EIS Access Report

Date of Report: 5 April 2018

Re: Catherine McAuley Catholic College, Medowie NSW

Assessment: Plans by: Webber Architects

SHEET NUMBER: 2544_03_0104_I

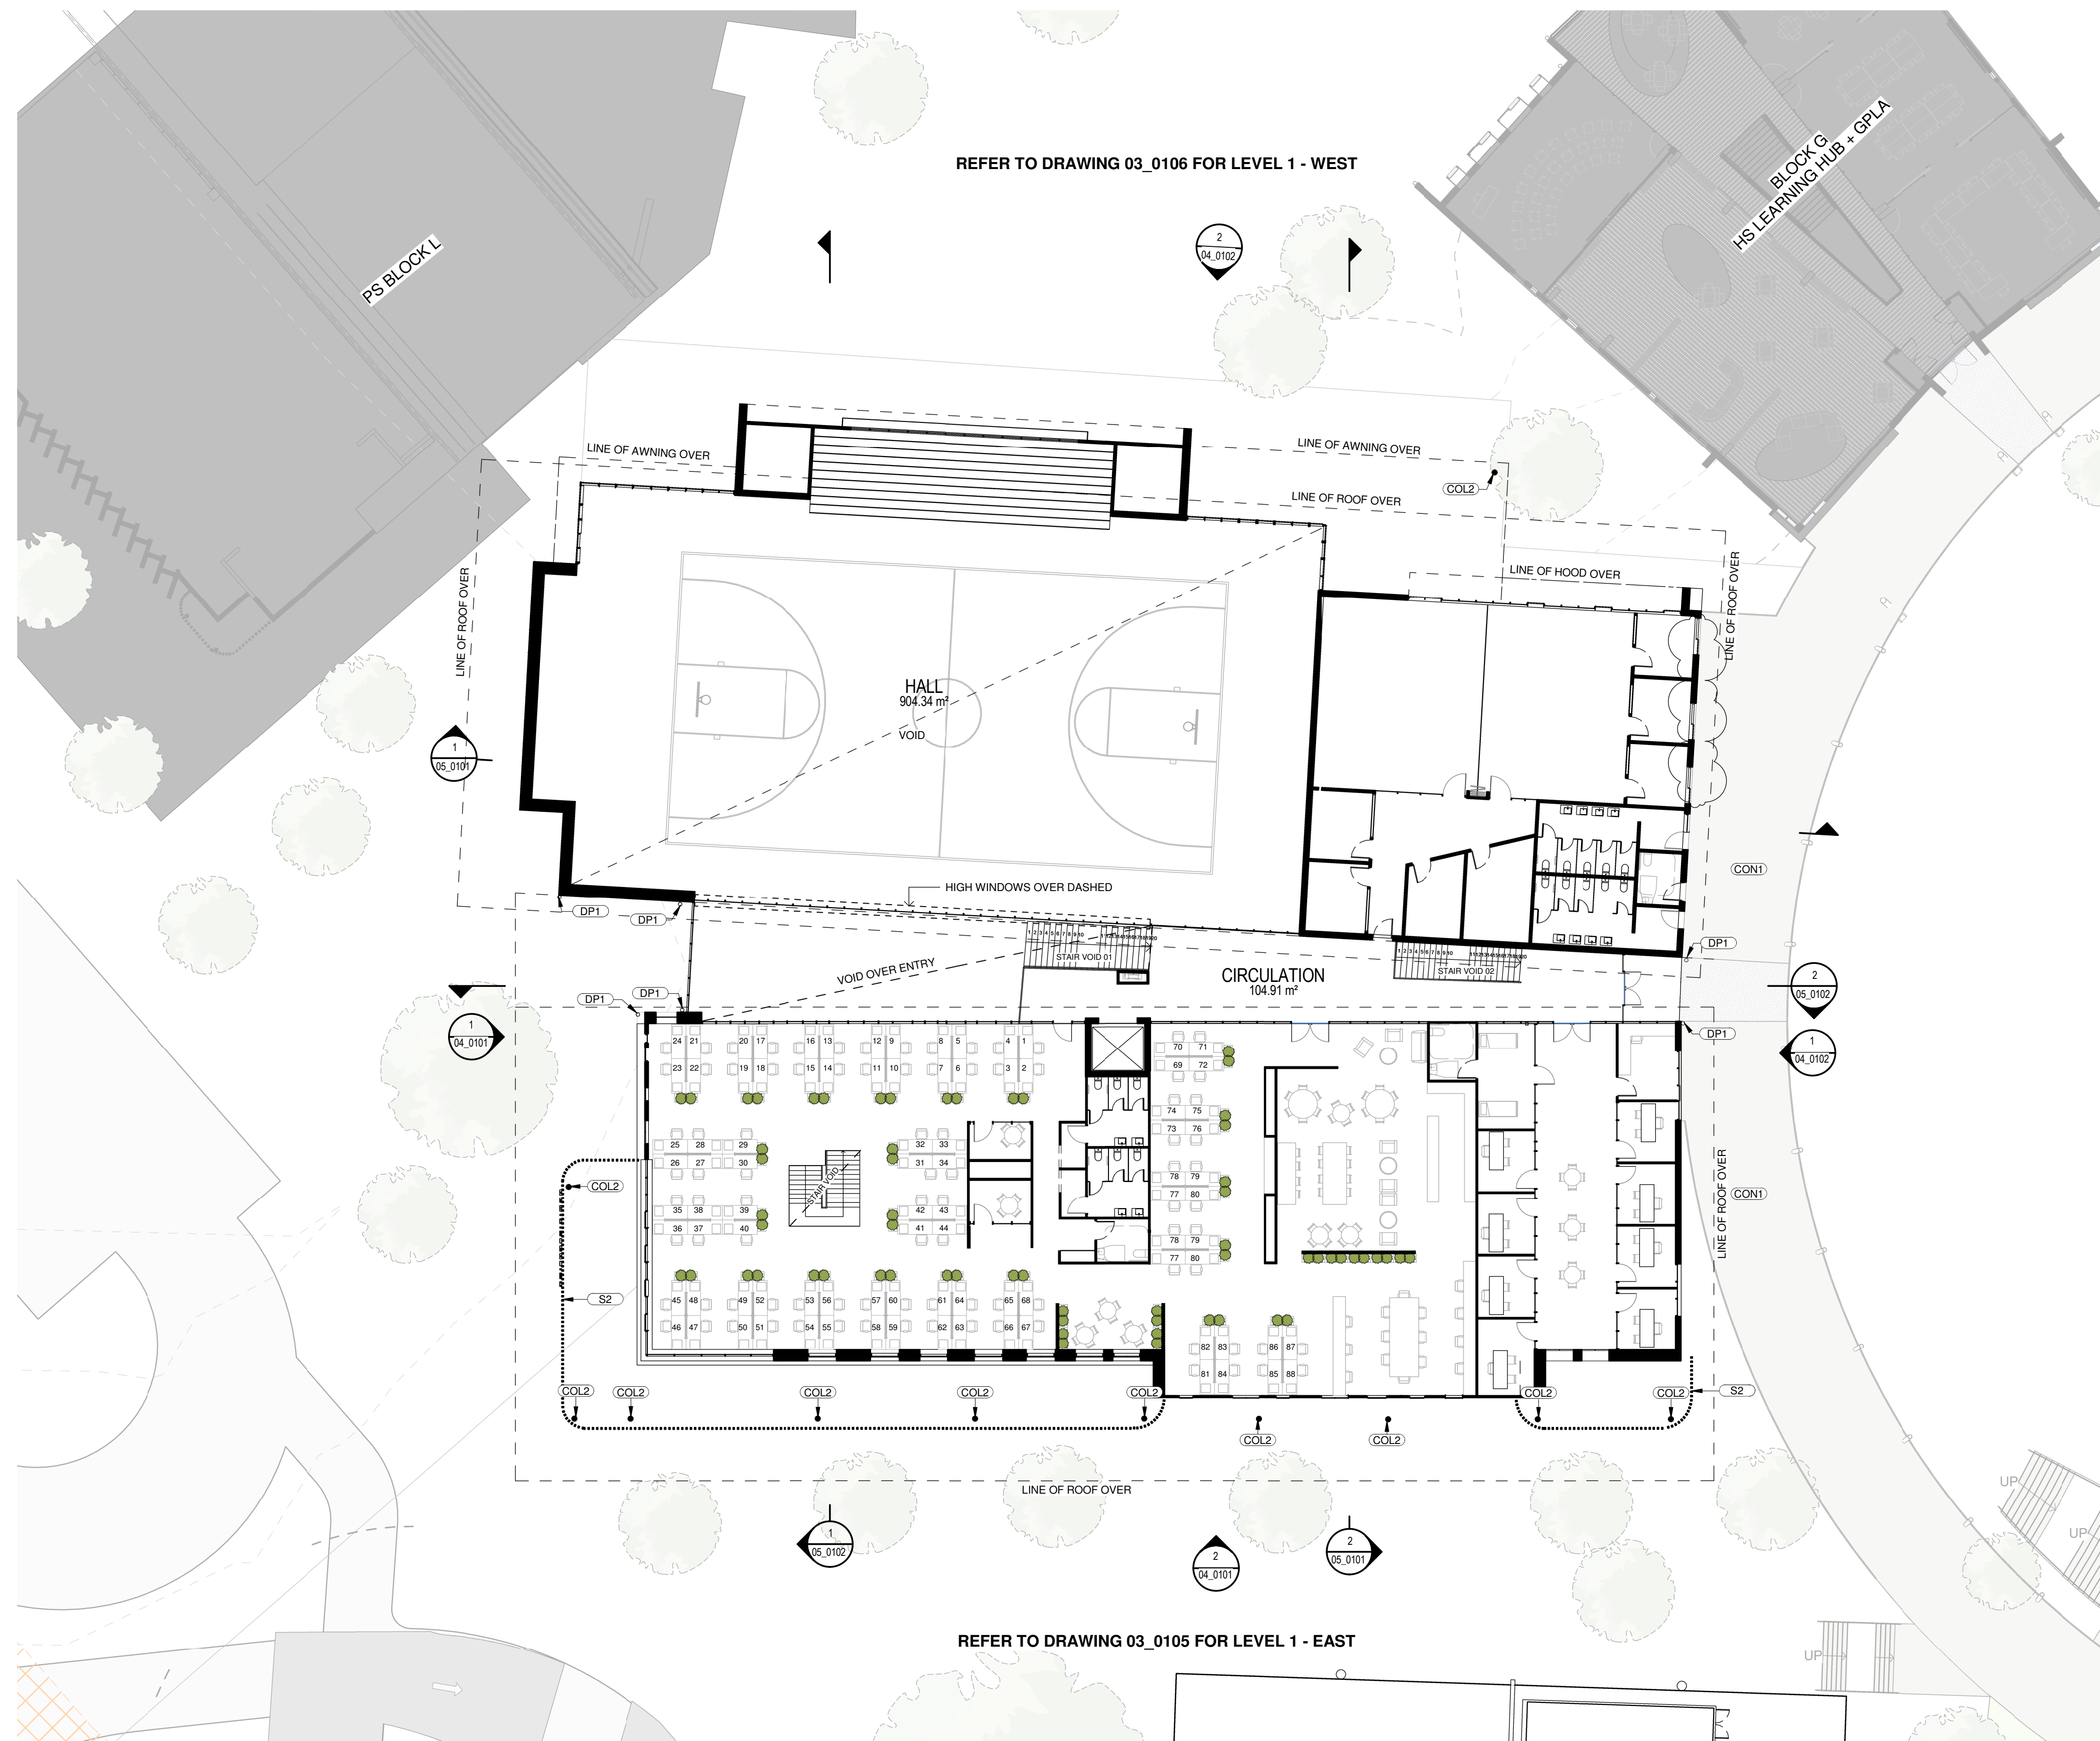
This includes the chapel mezzanine, high school hall stage, drama/dance/lecture room stage in Block A and seminar room in Block G (where a 170mm step is shown at the doorway). An accessible path of travel to these areas is to be confirmed prior to the issue of a construction certificate, otherwise an exemption under BCA D3.4 is to be demonstrated (note that chapel AV control duties would be possible for a wheelchair user and such facilities are to be in an accessible location).

<ul style="list-style-type: none"> a) The entrance to the music suite foyer (Block A, level 1) has reduced latch side circulation space internally. At least 530mm clearance is required. 		<p>Amend for CC</p>
<ul style="list-style-type: none"> b) The Block A hospitality and food technology sliding doors have joinery encroaching into latch side circulation space. At least 530mm clearance is required. 		<p>Amend for CC</p>
<ul style="list-style-type: none"> c) The confessional on the sacristy side of the chapel lacks latch side circulation space internally. At least 530mm latch side clearance is required. 		<p>Amend for CC</p>
<ul style="list-style-type: none"> d) There appear to be columns located within latch side circulation spaces for some Block D doorways. Ensure doors are recessed no more than 300mm and have circulation space appropriate to the direction of approach. 		<p>Confirm for CC</p>
